Appeal Decision

Appeal Ref: APP/T2350/D/24/3341790

2 Sunnyside Avenue, Wilpshire, Lancashire BB1 9LW

- The appeal is made under section 78 of the Town and Country Planning Act 1990 against a refusal to grant planning permission.
 - The appeal is made by Mrs Rubina Saleh against the decision of Ribble Valley Borough Council.
 - The application Ref. 3/2023/0927 dated 6 November 2023, was refused by notice dated 8 January 2024.
 - The development is described as the regularisation of boundary fence to front and side.
-

Proposed Retrospective Front and Side Elevation Boundary Treatment

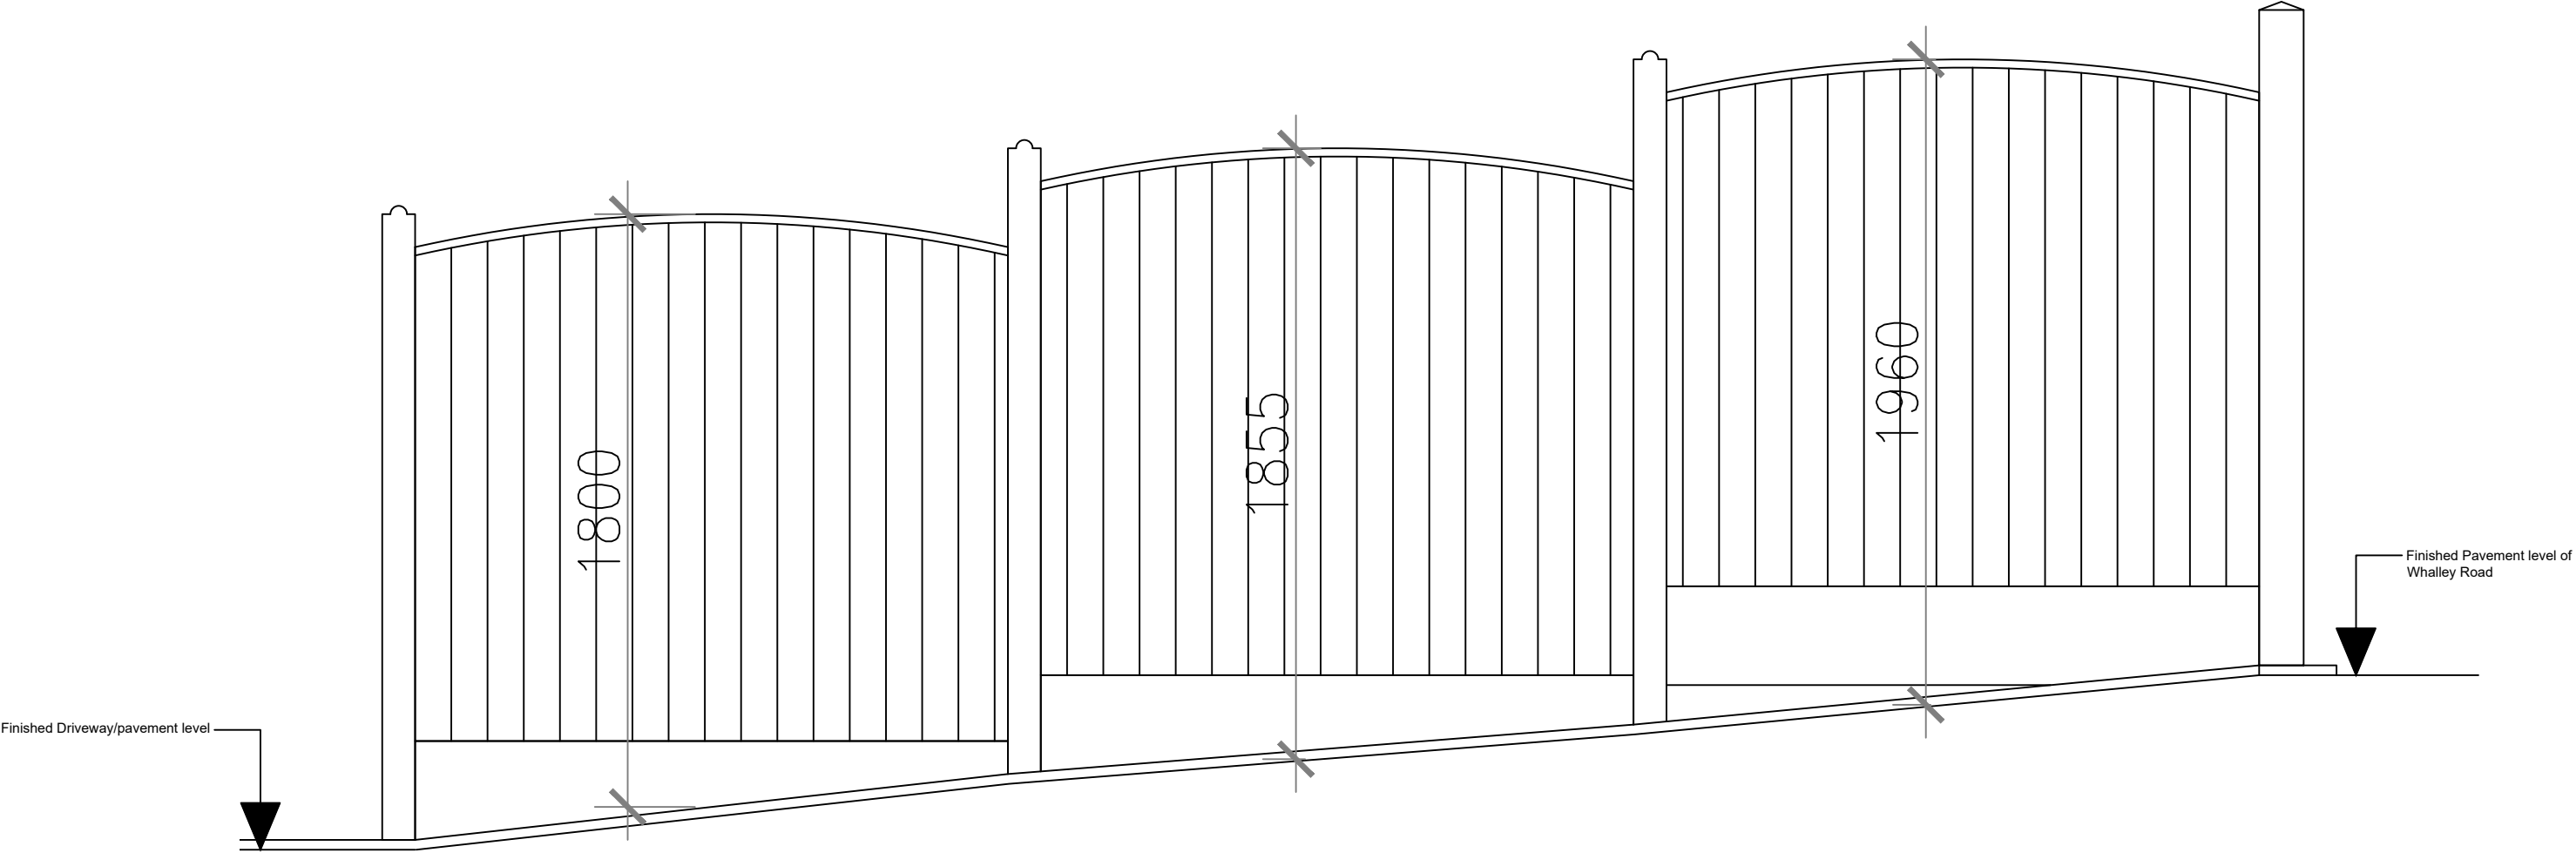
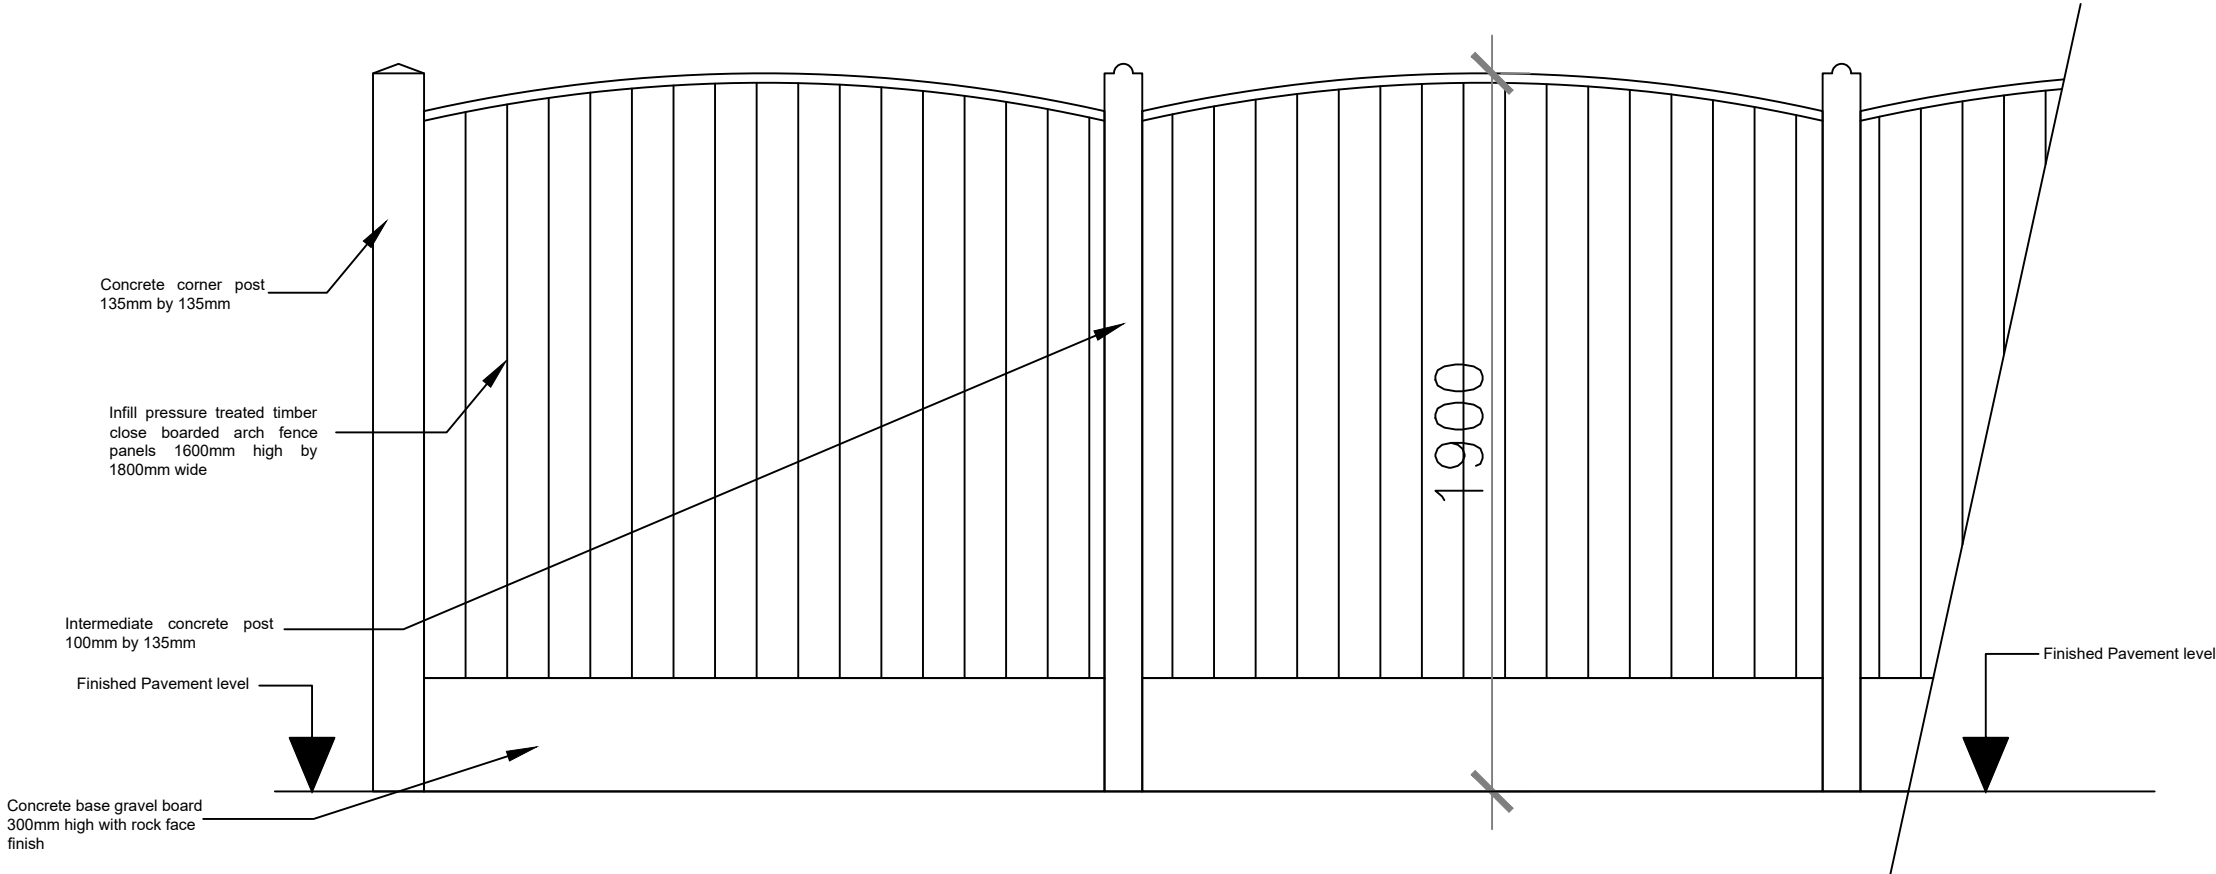
5. The fence as erected is a prominent feature and its location at the point where Sunnyside Avenue slopes down from Whalley Road means that it is highly visible in both directions when driving along Whalley Road. Its height closed boarded design and materials are a stark contrast with the existing boundary treatments found along this length of Whalley Road. As such it is an incongruous feature which fails to integrate with its surroundings and at odds with the prevailing character of the immediate streetscene. Further, it introduces a sense of enclosure and has a harmful visual impact on the immediate character and appearance of the area.

6. I appreciate that the fence could be stained/painted in a more appropriate colour but this would not mitigate the harm caused by the excessive height of the fence nor fully replicate the softer landscaping generally found in this area. I do not therefore consider that a condition could adequately mitigate the harm and make the proposal otherwise acceptable.
